SSD 7382 UTS Central, Broadway Precinct

Detailed Response to Submissions – July 2016

Existing June 21st 1:00pm Shadow

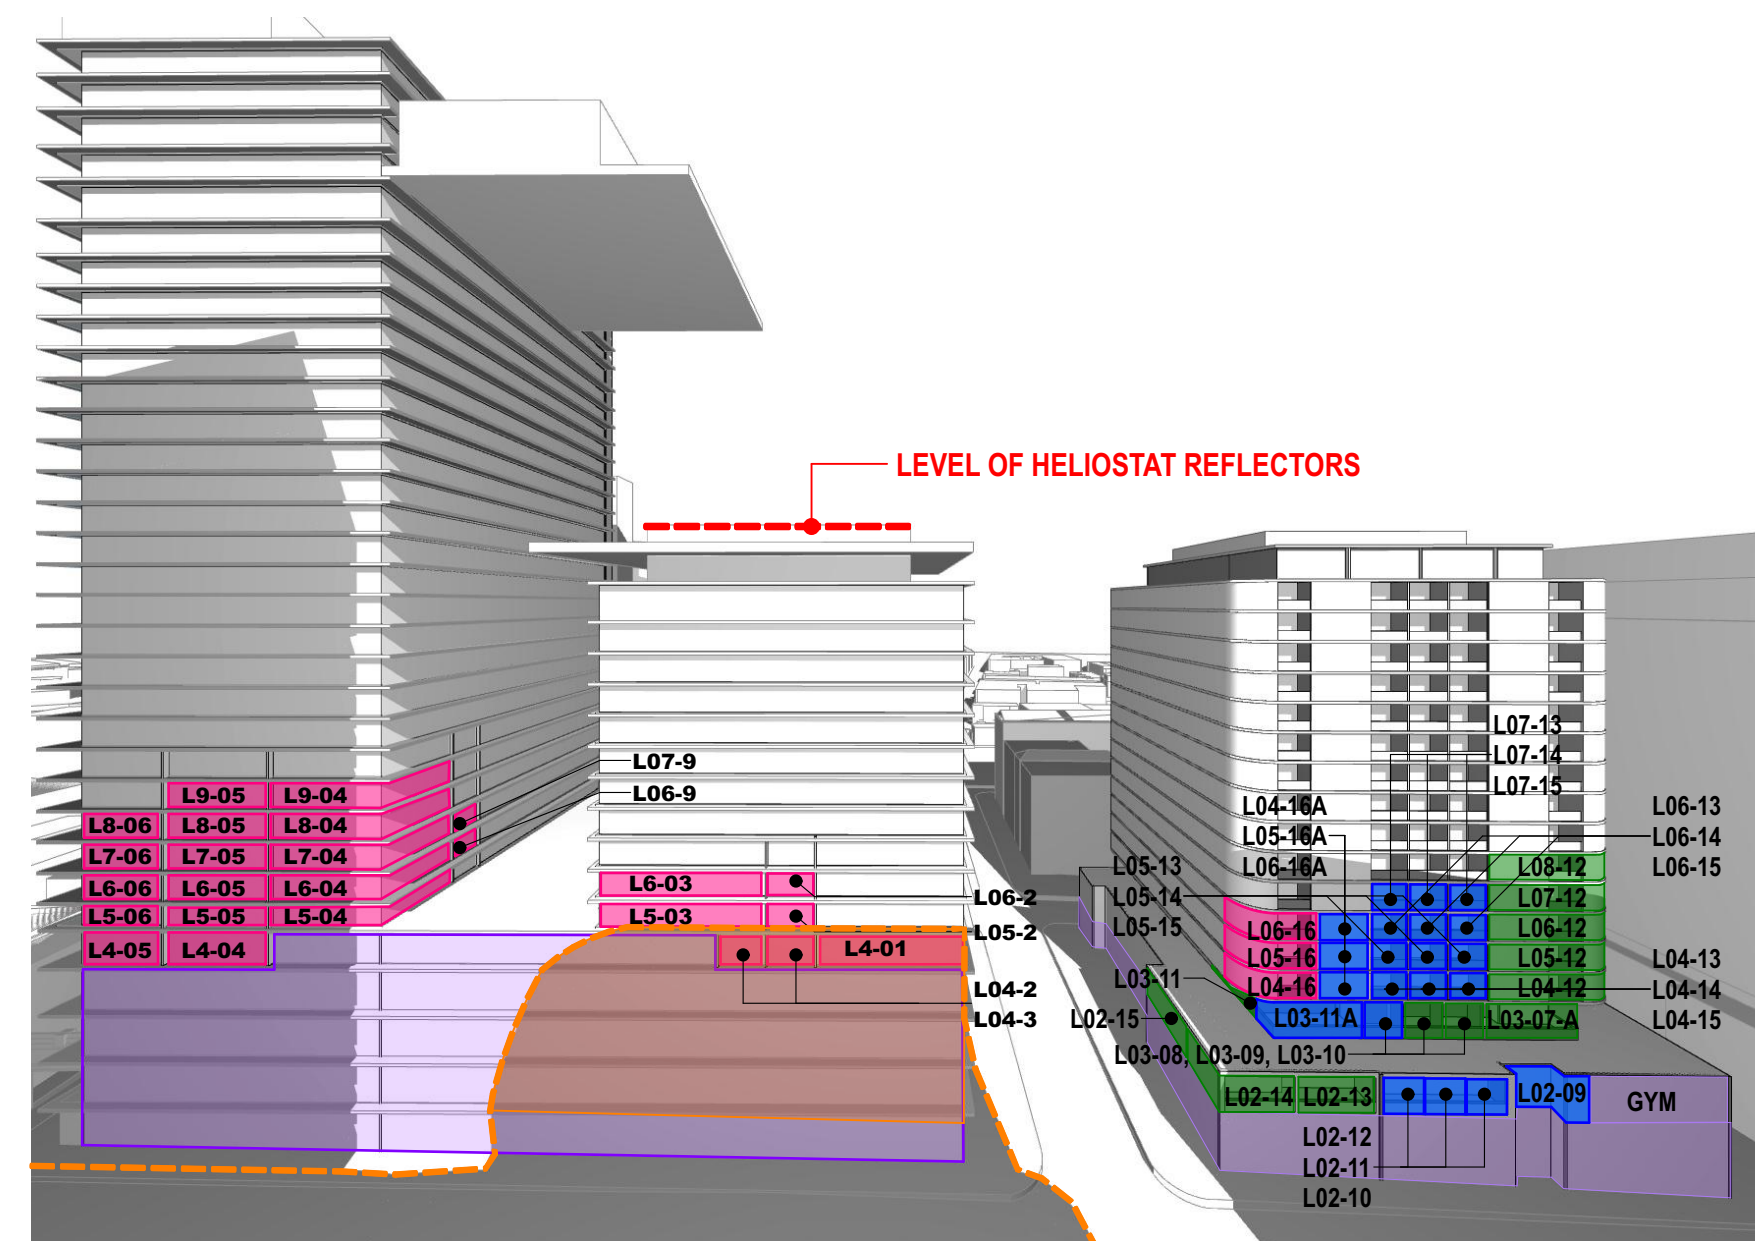
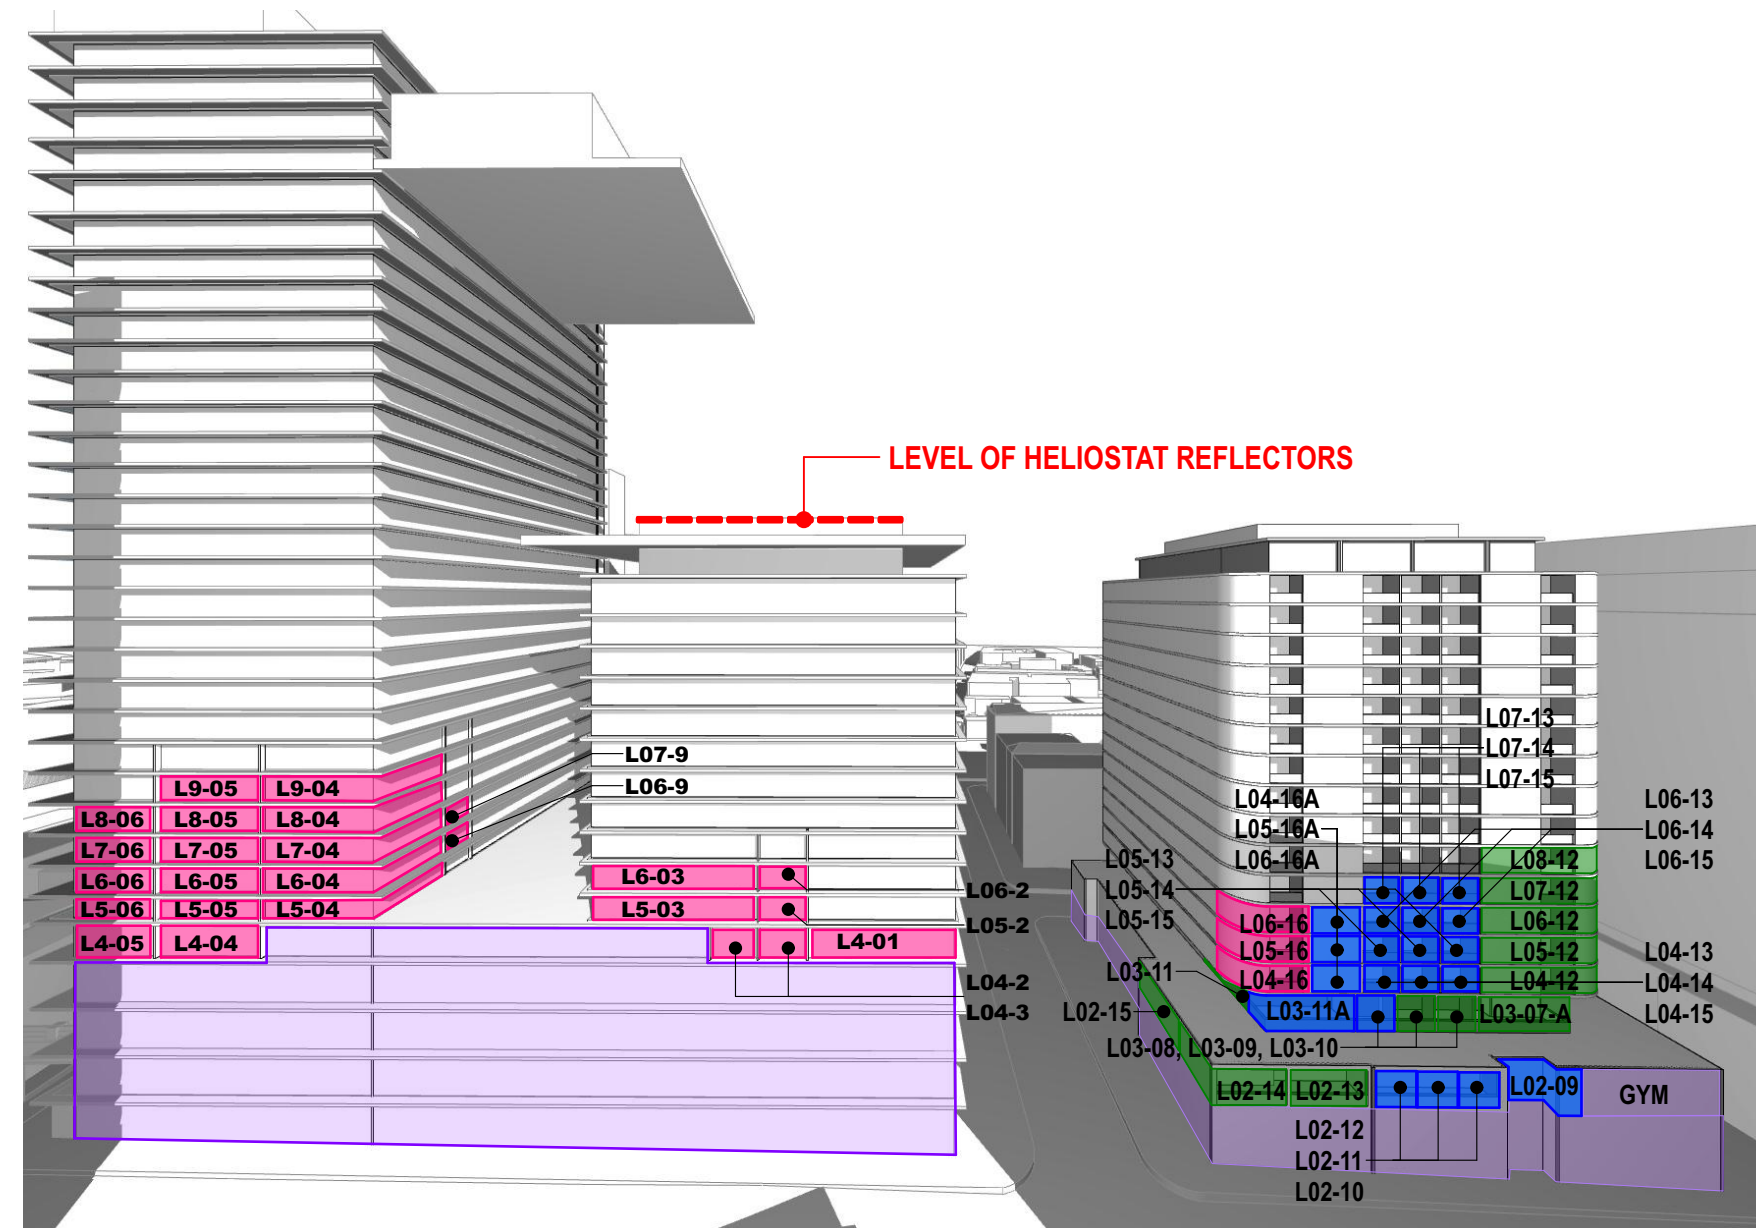
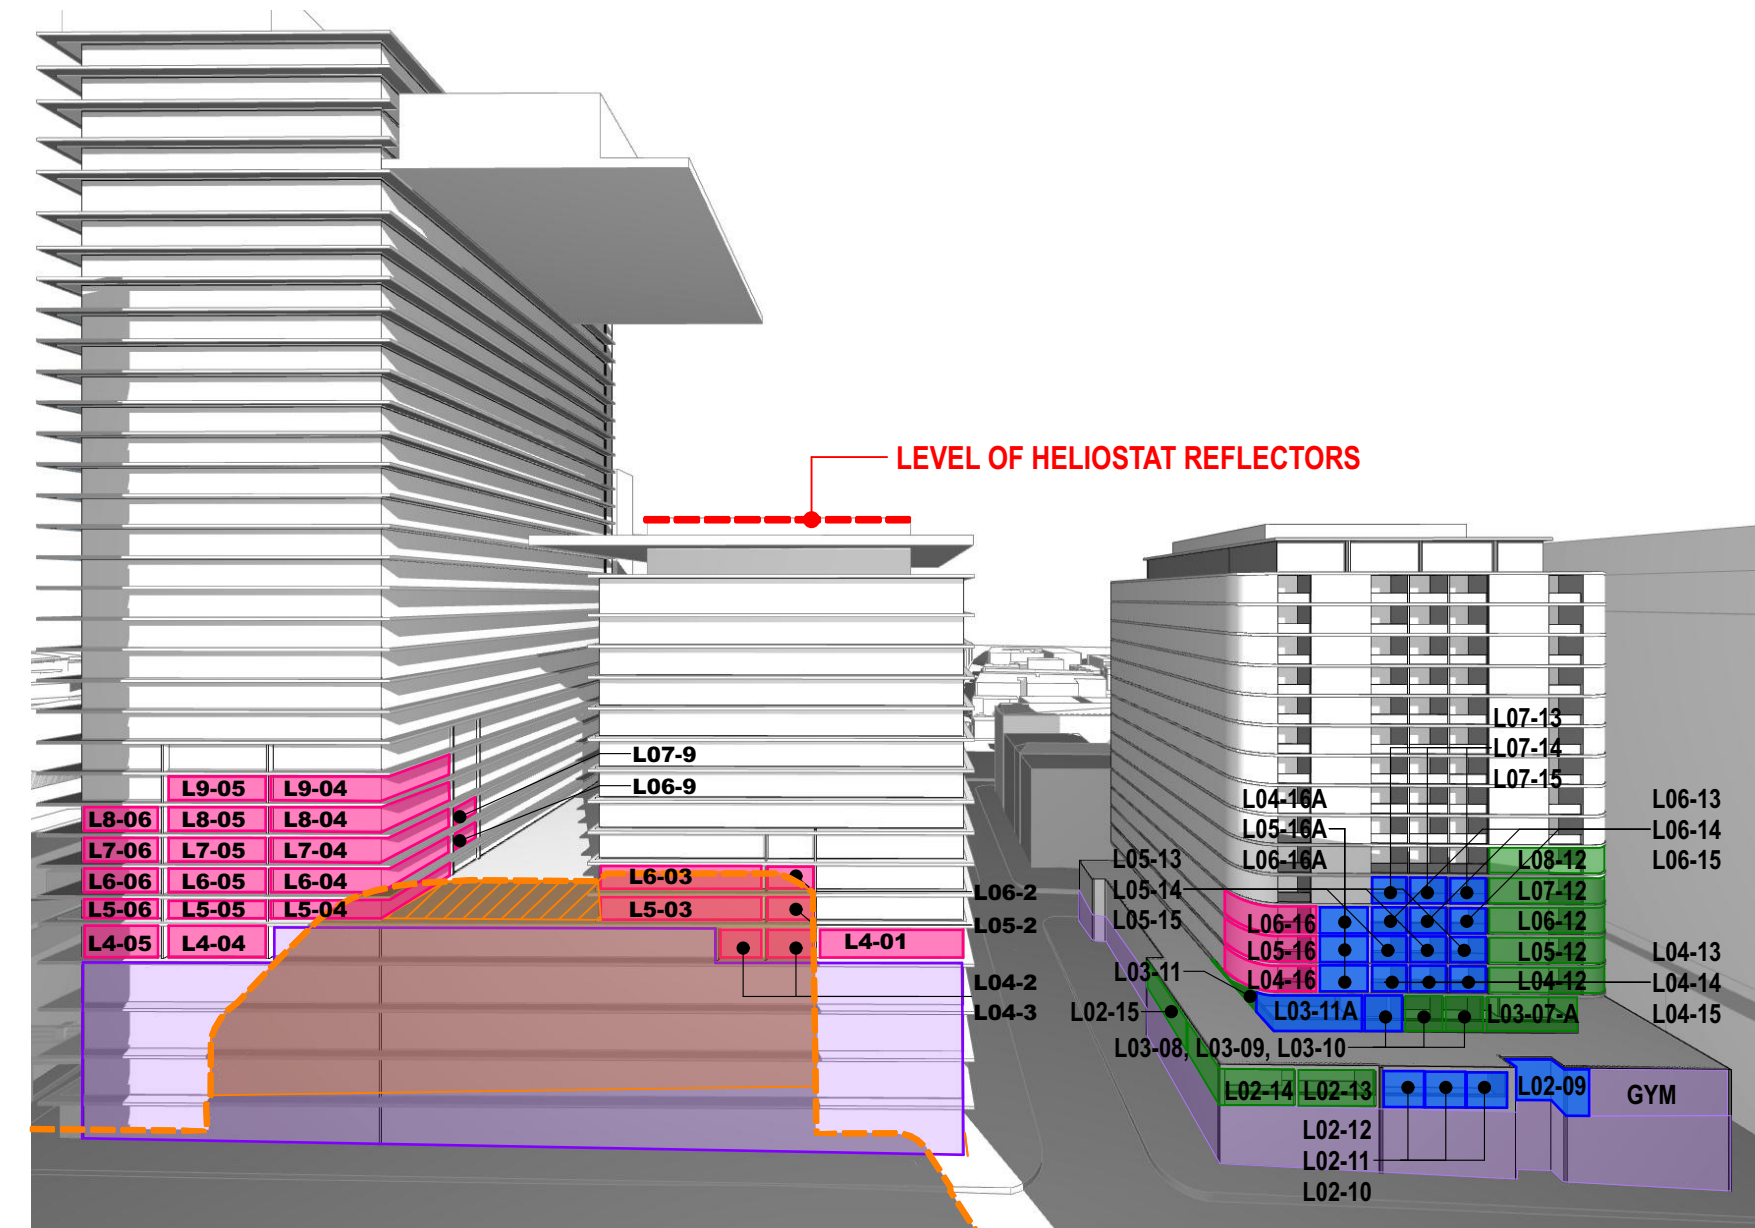
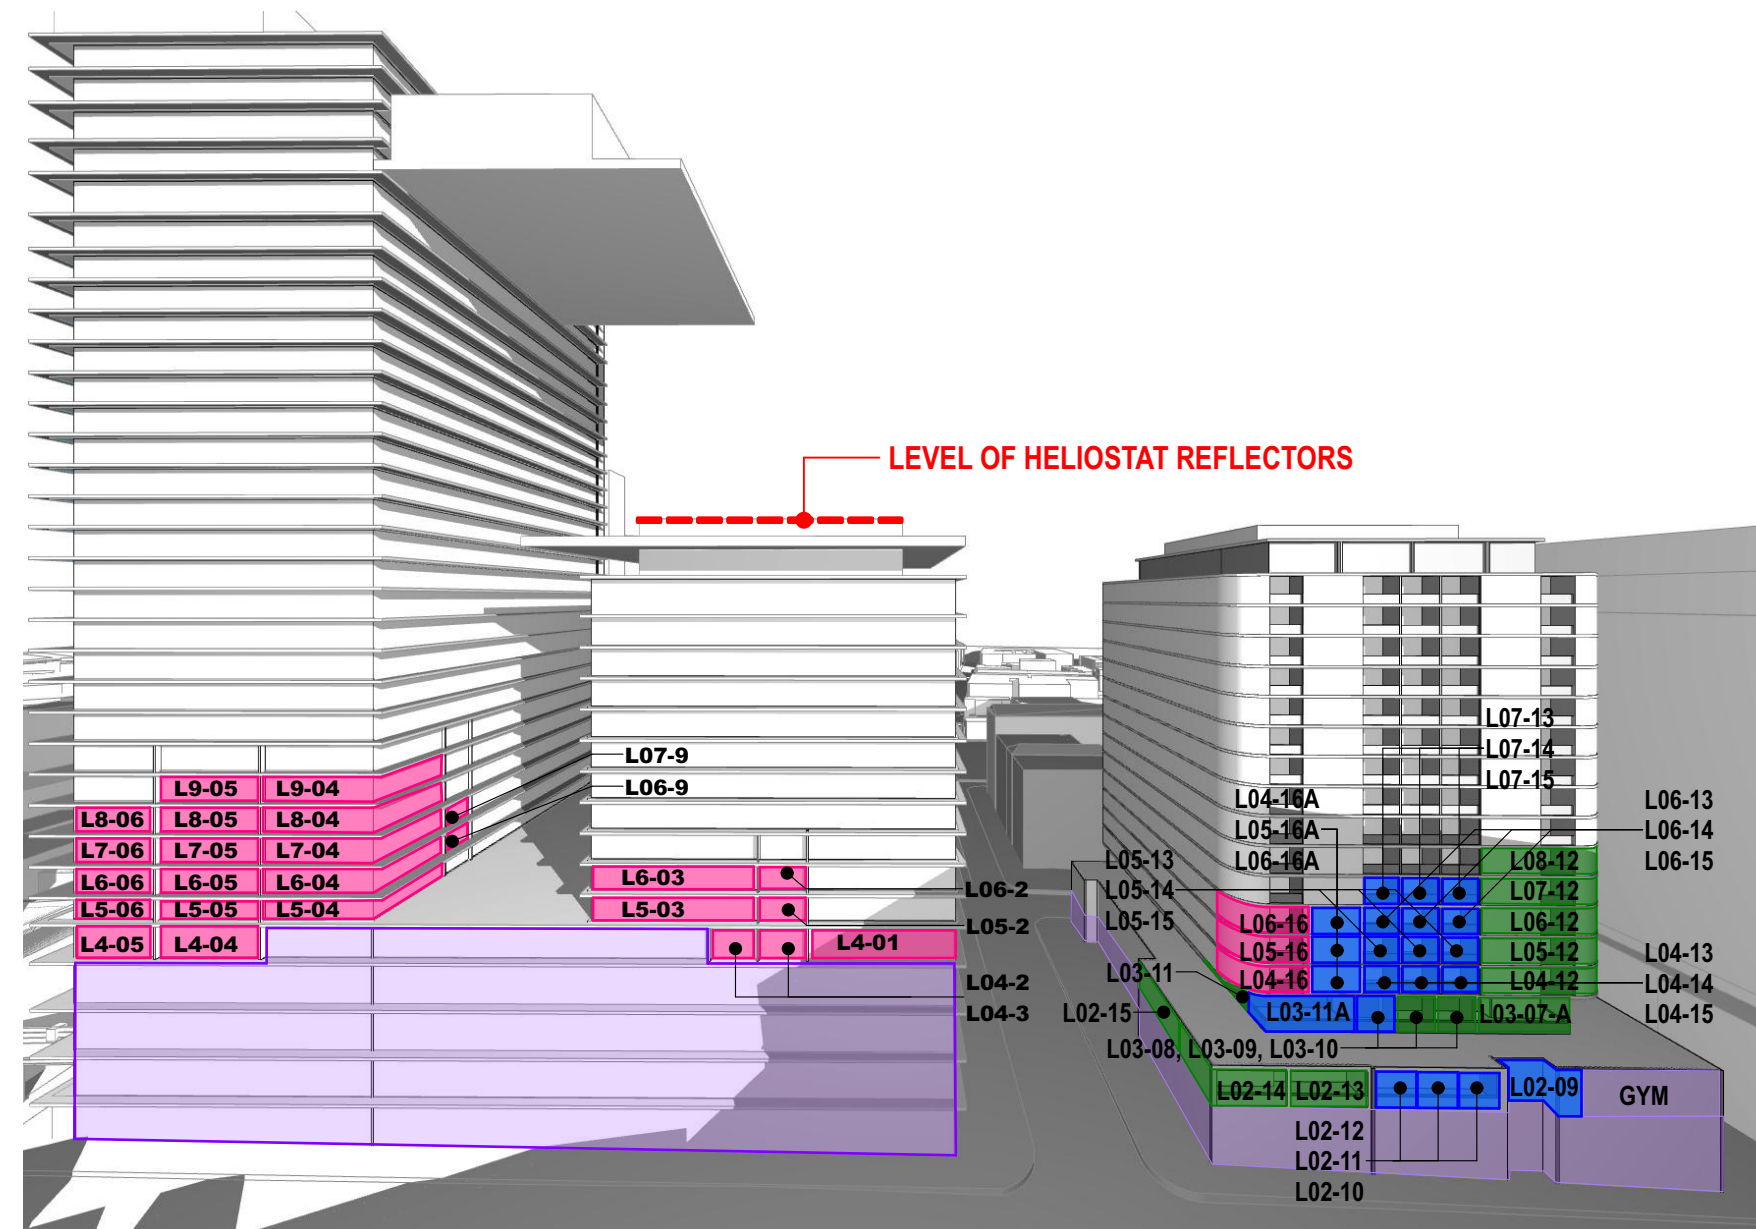
<p>Environmental and Residential Amenity</p> <p>5. The Department is concerned with the overshadowing impacts from the proposed building on the residential properties within Central Park and a further quantitate analysis of solar access to be retained and lost for all dwelling impacts by the proposal must be provided, including additional analysis of whether the proposal would impact on any heliostat solar collectors for building within Central Park.</p>	<ul style="list-style-type: none"> - FJMT and JBA have completed a detailed analysis on the overshadowing impact from the proposed building on the residential properties within Central Park as outlined within the main report. - The holistic assessment of the various amenity considerations for Block 1 demonstrates that notwithstanding the lower achievement of direct sunlight access, Block 1 will deliver a high level of residential amenity. - The proposed development is the same height as the lower tower of No. 1 Central Park and does not impact on the roof level of the lower tower where the reflectors are located or the roof level of the higher tower where the heliostat is located.

Solar & Daylight Access <p>In order to demonstrate that the proposed development is able to comply with Objective 3B-2 of the Apartment Design Guide and Section 4.2.3.1 of the Sydney Development Control Plan 2012, a solar analysis should be provided of the surrounding buildings and rooftop on which the heliostat solar collectors are located. A daylight report and LUX level map of affected apartments should also be submitted.</p>		<ul style="list-style-type: none"> - Detailed elevational shadow diagrams for Central Park (One Central Park and Block 1) have been prepared by FJMT (Attachment B) for June 21 (7.30am to 3pm) illustrating: <ul style="list-style-type: none"> - Shadows Cast by the modified Concept Plan (MOD 5 envelope) - Shadows cast by UTS Central SSDA. - Further, the existing building shadows cast over Central Park have been previously prepared and are also submitted with this report. - The proposal has been reviewed against the following: <ul style="list-style-type: none"> - <i>Objective 3B-2 of the Apartment Design Guide.</i> - <i>Section 4.2.3.1 of the Sydney Development Control Plan 2012.</i> - As outlined within the main report, the holistic assessment of the various amenity considerations for Block 1 demonstrates that notwithstanding the lower achievement of direct sunlight access, Block 1 will deliver a high level of residential amenity.
